BUILDING PERMIT

Located At 17 SHERMAN ST

Job ID: 2012-07-4458-ALTR

has permission to Remove & replace exist 2 story deck, existing roof
provided that the person or persons, firm or corporation accepting this permit shall comply with all of the provisions of the Statues of Maine and of the Ordinances of the City of Portland regulating the construction, maintenance and use of the buildings and structures, and of the application on file in the department.

DECK REPLACEMENT  
15-17 SHERMAN ST.

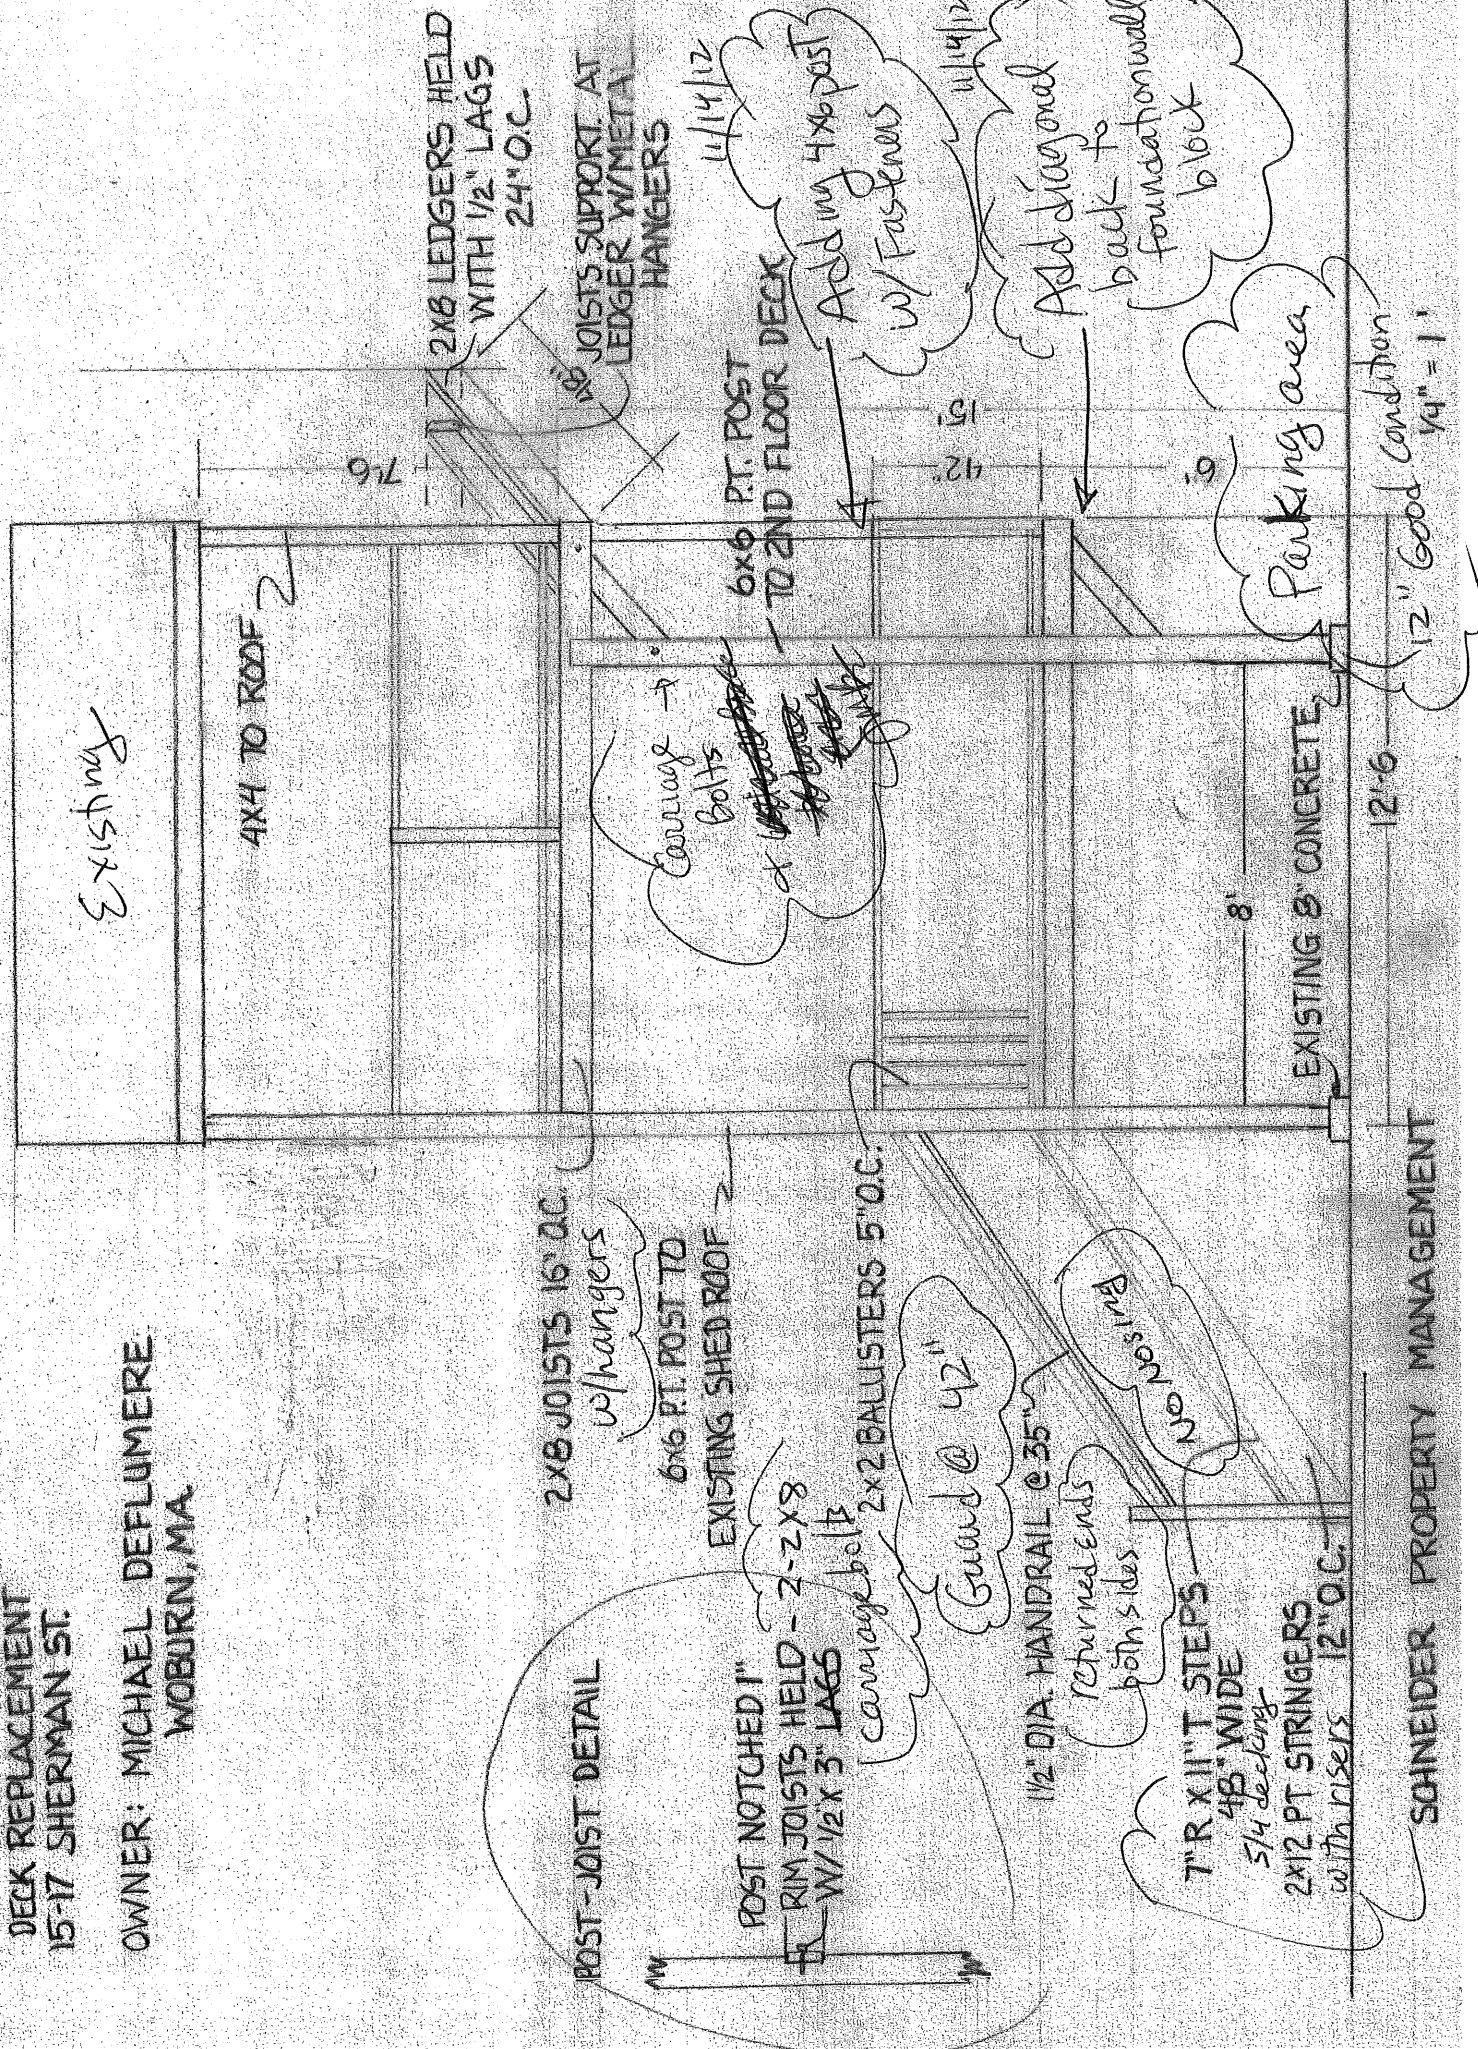
11/14/12 - Met w/ Bill Howe to discuss codes & design of replacement structure. Due to the width of deck (4') and Roof attachment and no internal access to Floor system, Lateral connection is not required. See notes on ~~plan~~ for additional post & diagonal brace. JMB
